CITY OF ALBUQUERQUE

September 22, 2022

**Re: Champion Xpress
5101 Lomas Blvd. NE
30-Day Temporary Certificate of Occupancy
Transportation Development Final Inspection**
Architect's Stamp dated 5-11-22 (J17-D010)
Certification dated 09-08-22

DATE 5/11/2022	SHEET G3A
SCALE:

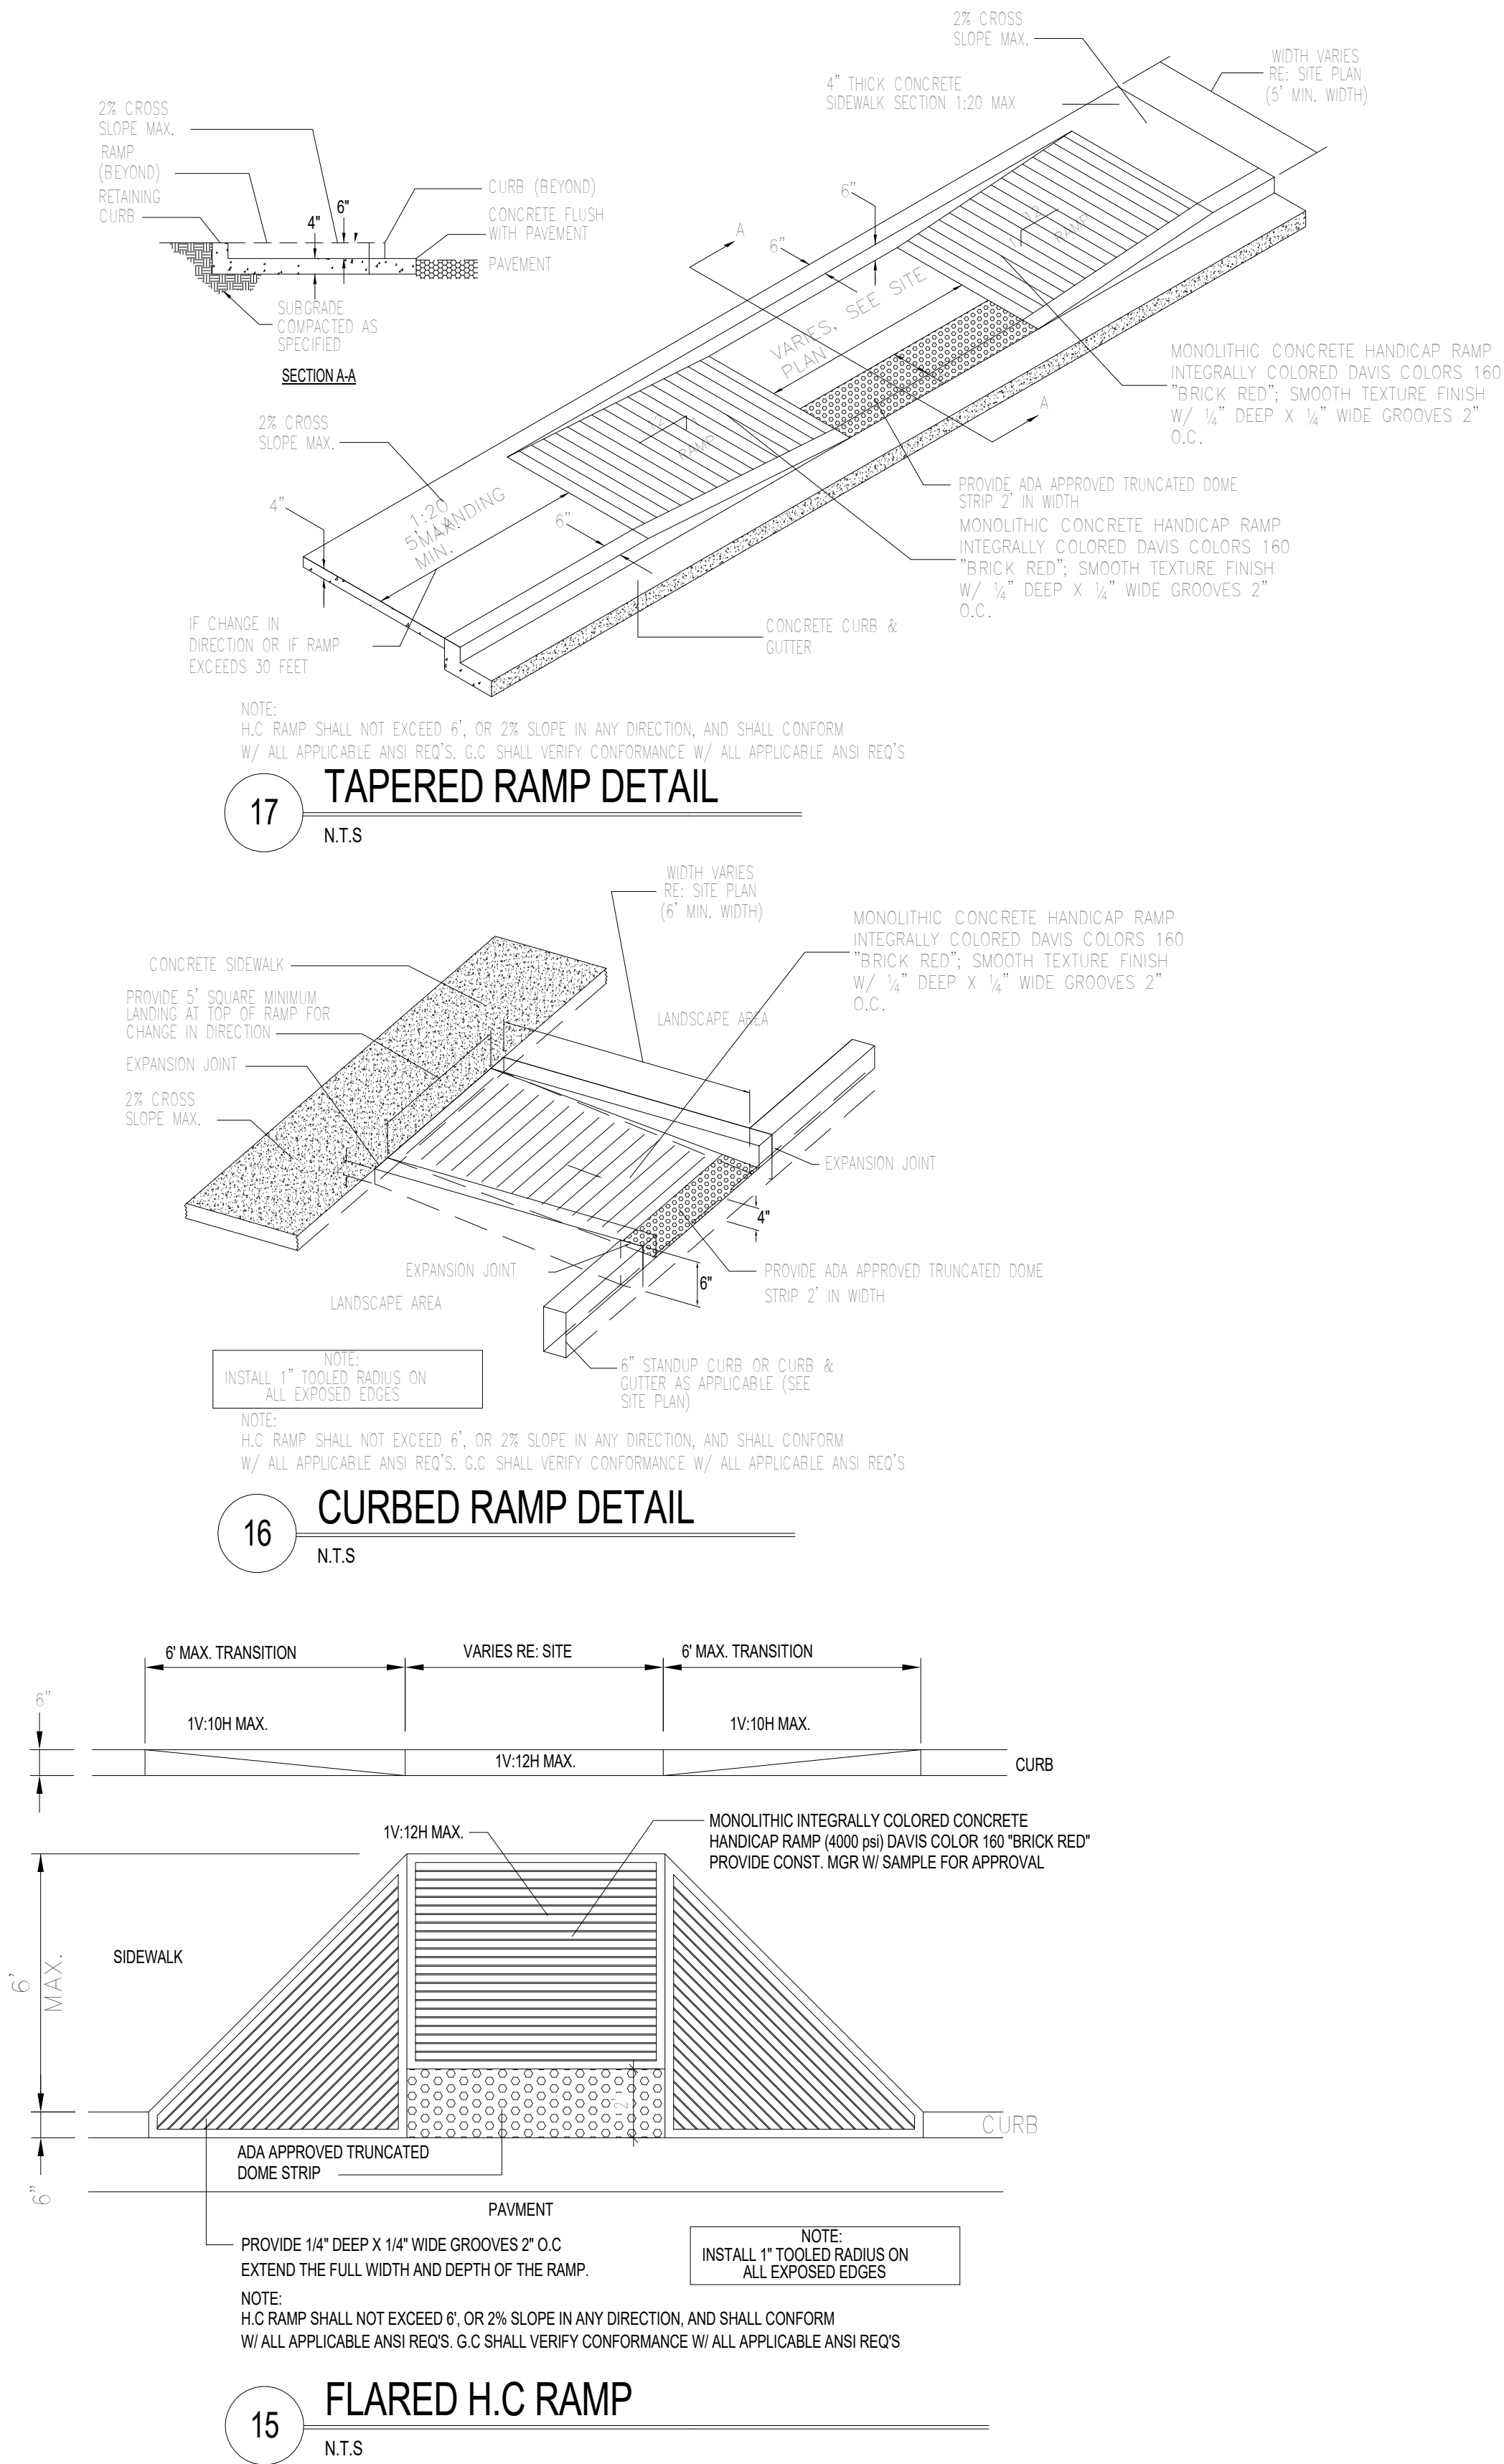
- Per Approved TCL, Curb Return design driveway accesses must be built off Lomas Blvd. and Manzano St.
- Per the approved TCL key note 15, ADA curb ramp at the corner of Lomas and Manzano must have Truncated Domes installed.
- 6 ft. wide ADA pathway need to be provided from the ADA aisle to the building entrance. Please note that per site visit, there is only 3 ft wide pathway has been built from the ADA aisle to the building entrance.
- Please build parallel parking spaces per approved TCL.
- Anchor down Bike Rack.
